Stonestreet Green Solar

Responses to Deadline 2 Submissions

PINS Ref: EN010135
Doc Ref. 8.10
Version 1
Deadline 3
January 2025

Drawing Title: **Illustrative Landscape Strategy Plan Sheet 2 of 5 Not for Approval**

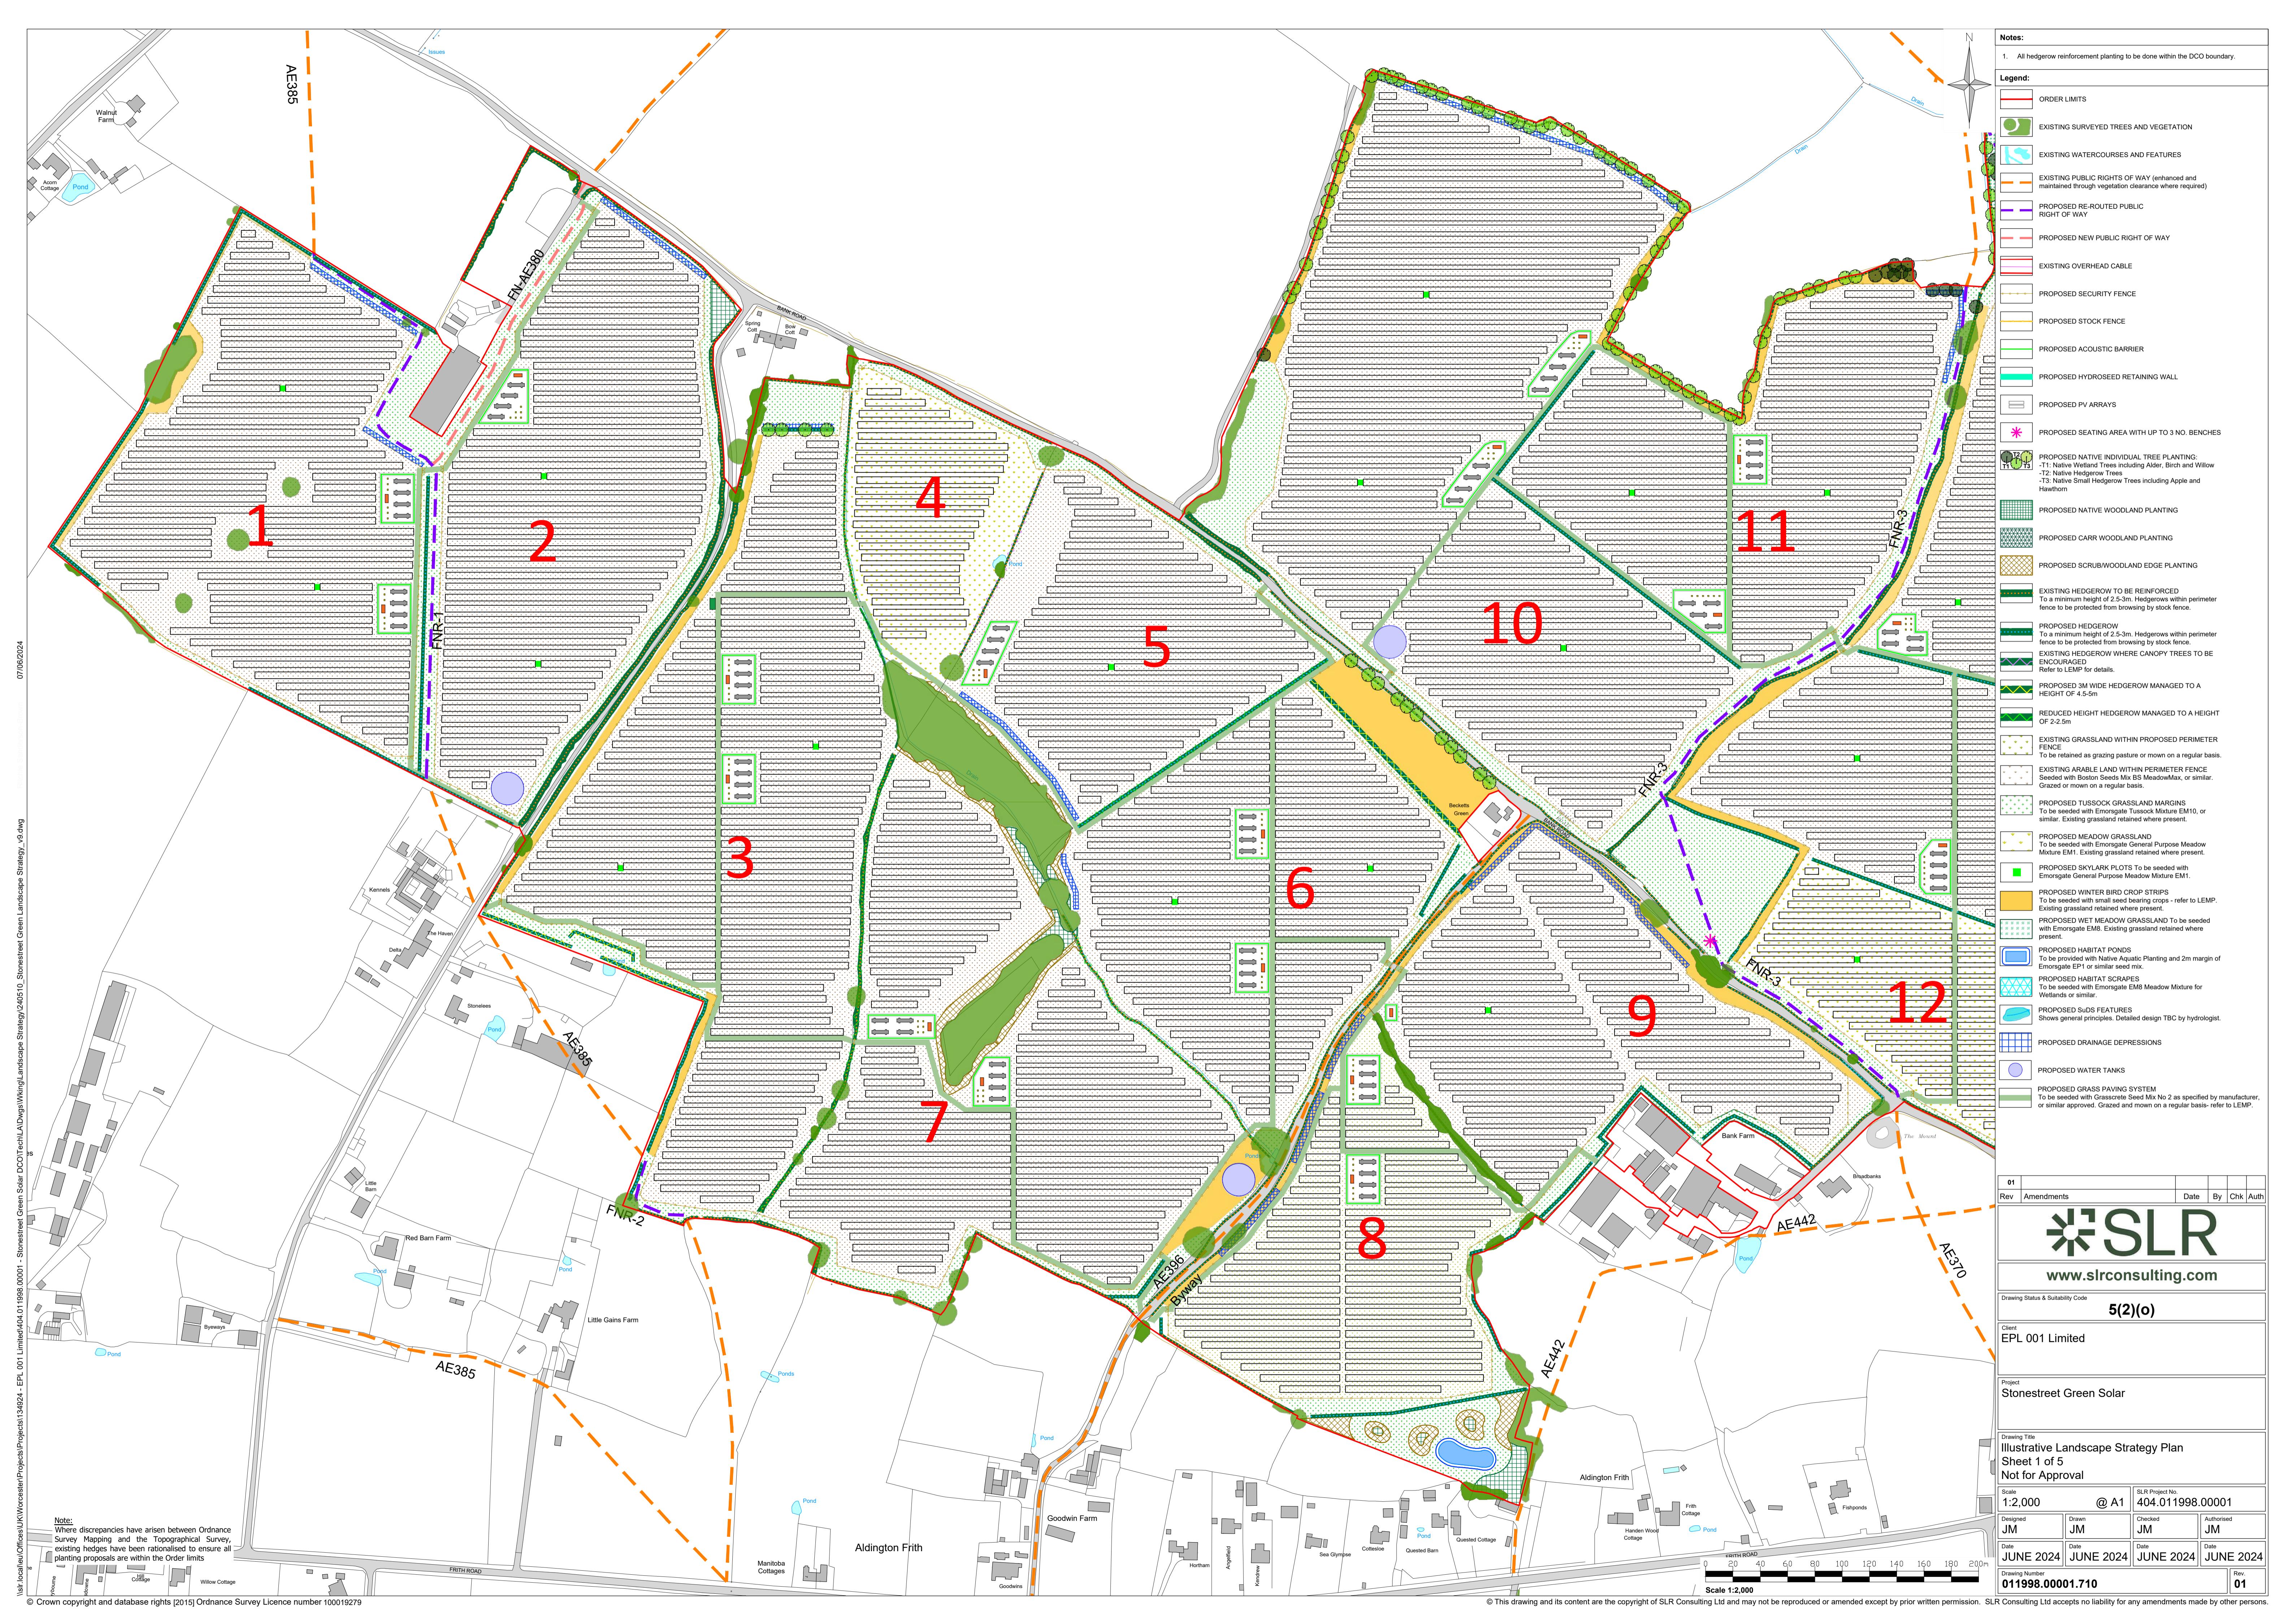
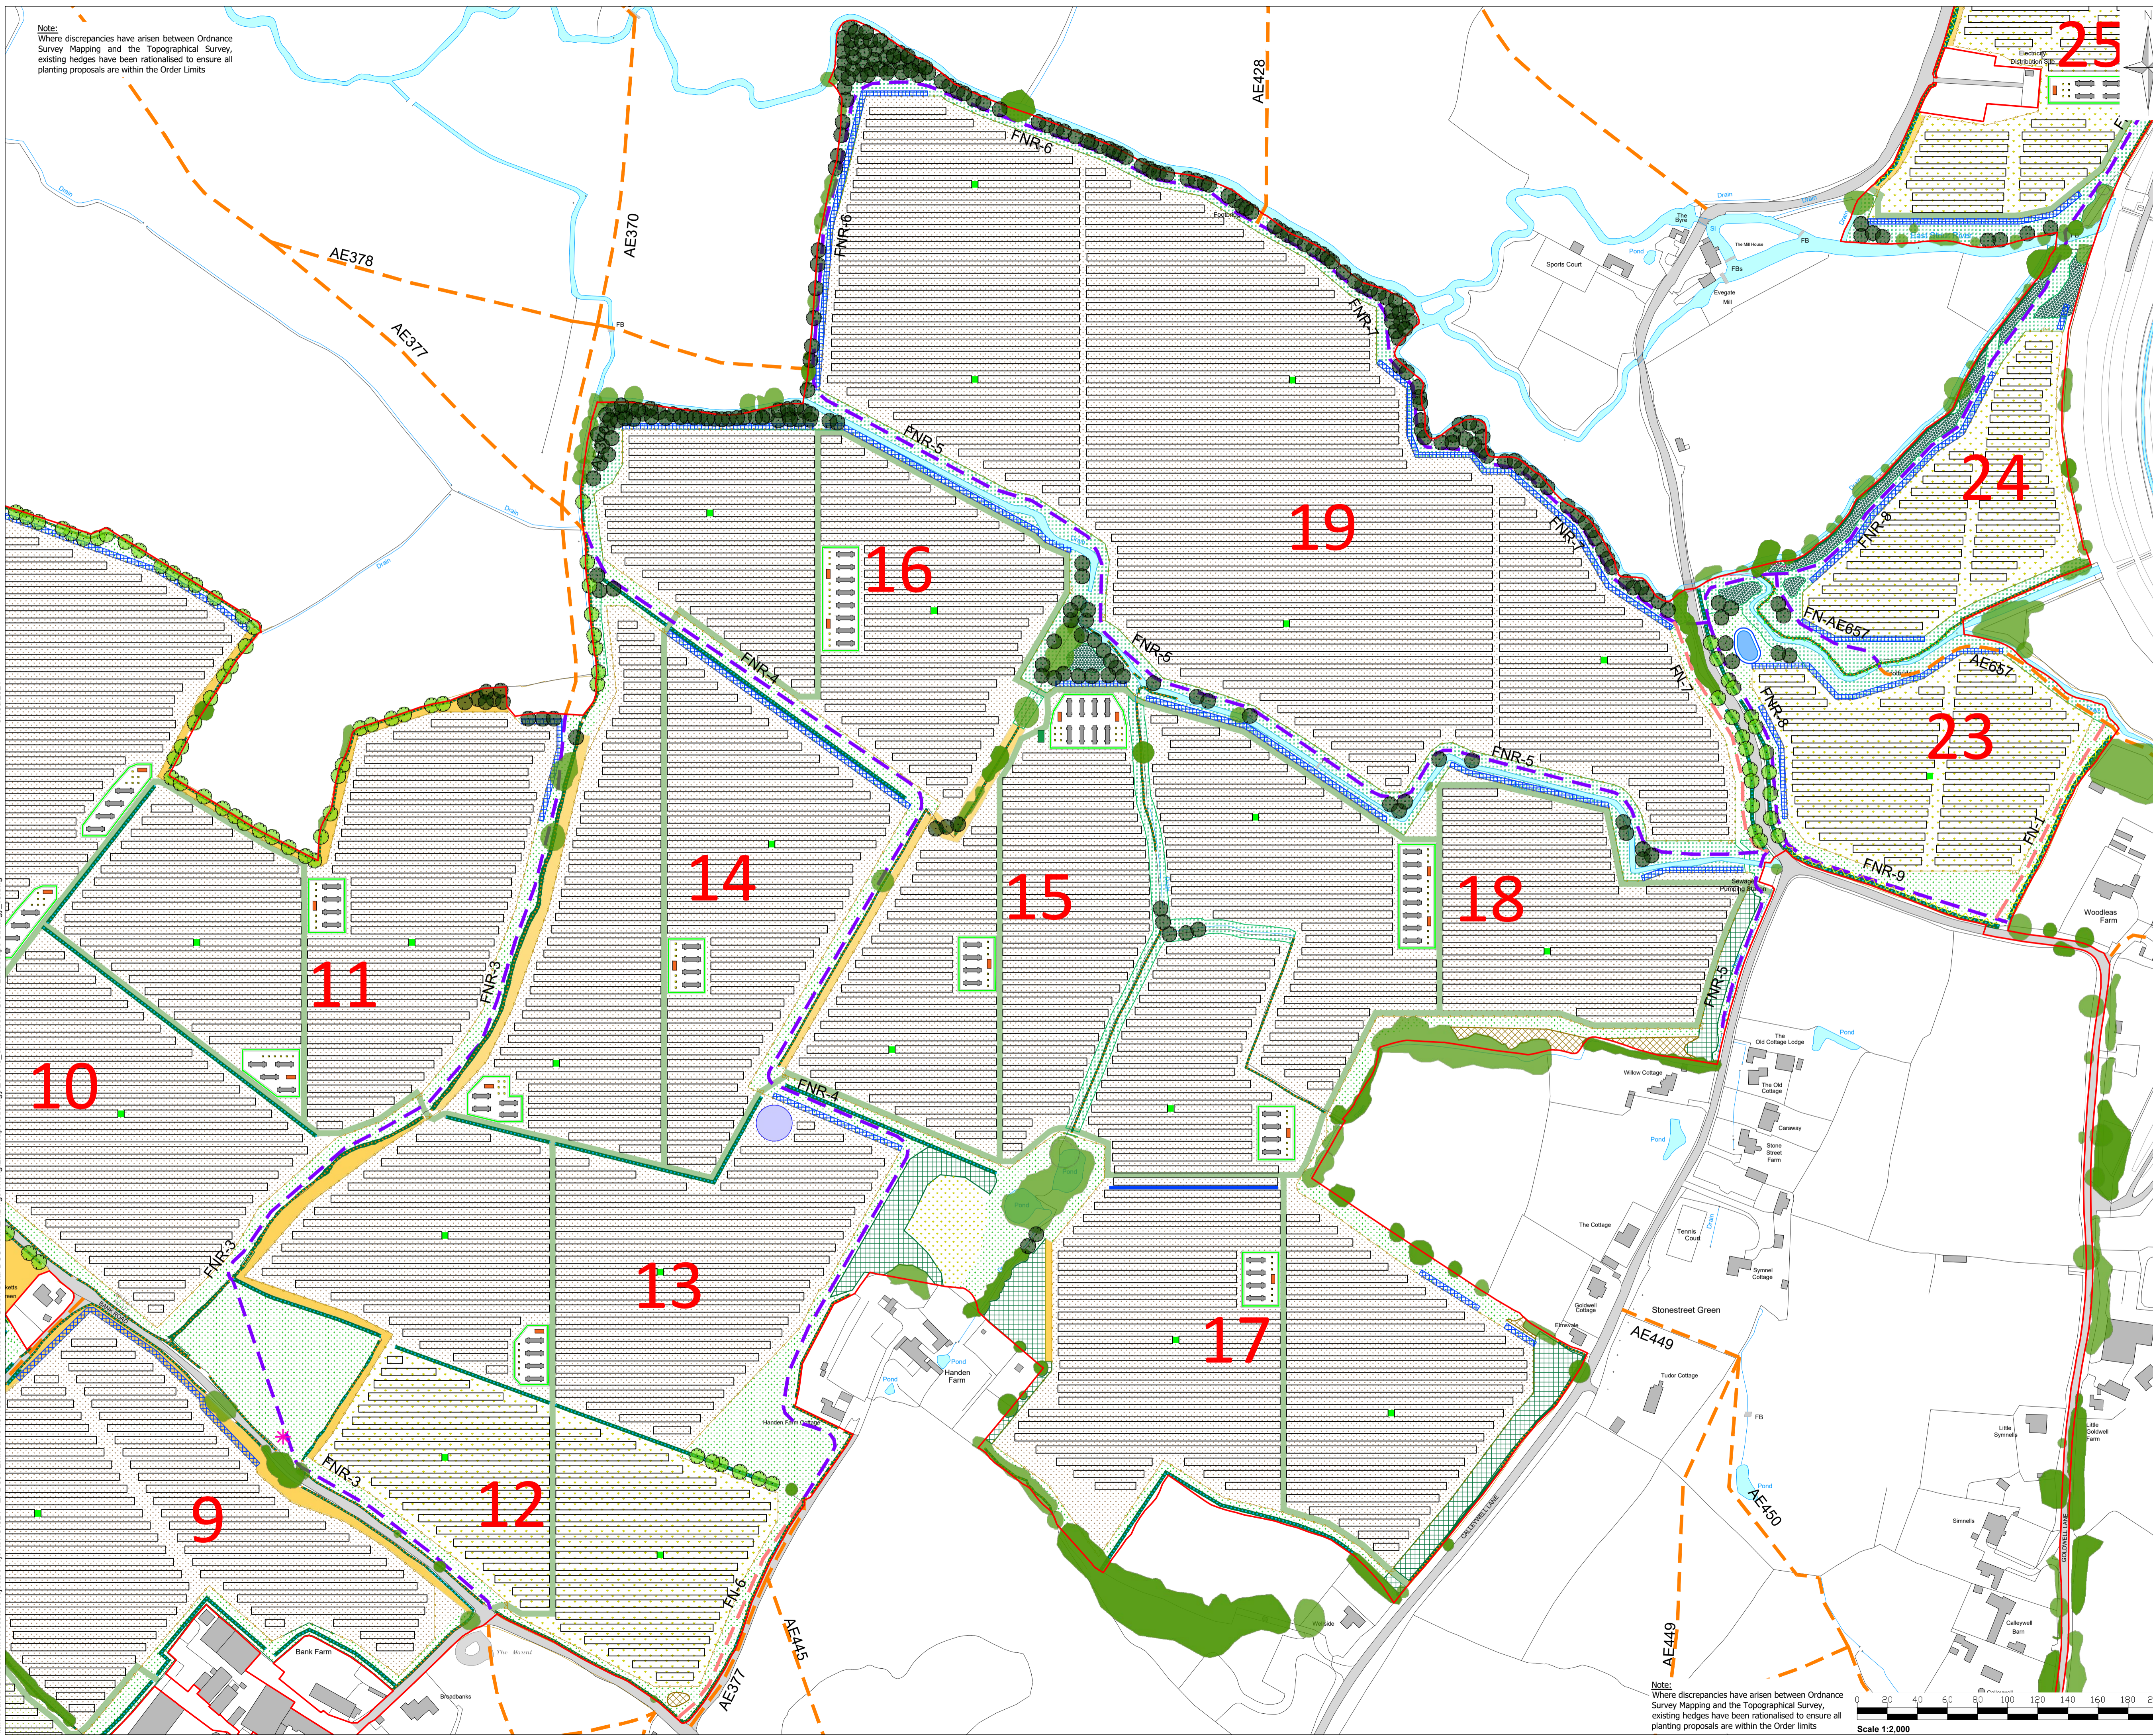
destined to be Tussock Grassland. This may suit land like this which routinely floods each winter but is hardly suitable as replacement Skylark habitat particularly when this species favours short grassland or arable fields which are not close to woodland (because of predation risk). Note fields 27 and 29 are relatively small (not optimal for Skylark), adjacent to established hedges, sporadic woodland by the river and Backhouse Wood. This leaves the so-called “Skylark Plots” to achieve compensation for lost nesting habitat which are the tiny green squares on the plan below which is an extract from the Applicant’s illustrative plan Doc. Ref 2.7 (note, not for approval).

Possibly the Applicant’s ecologists consider that the recommended 2 No.16 m² Skylark plots/HA recommended for increasing Skylark numbers in autumn sown cereals (as shown below) is equally applicable when located in the middle of the metal and glass of a solar array. If so, where is the evidence that this has worked in the same way to increase Skylark nesting, and what happens if this mitigation proves to be inadequate? Will some of the panels be removed?

Please refer to Table 3-2: Response to Aldington and Mersham Support Group, ‘Biodiversity’, **Responses to Relevant Representations (Doc Ref. 8.2)** [\[REP1-061\]](#).
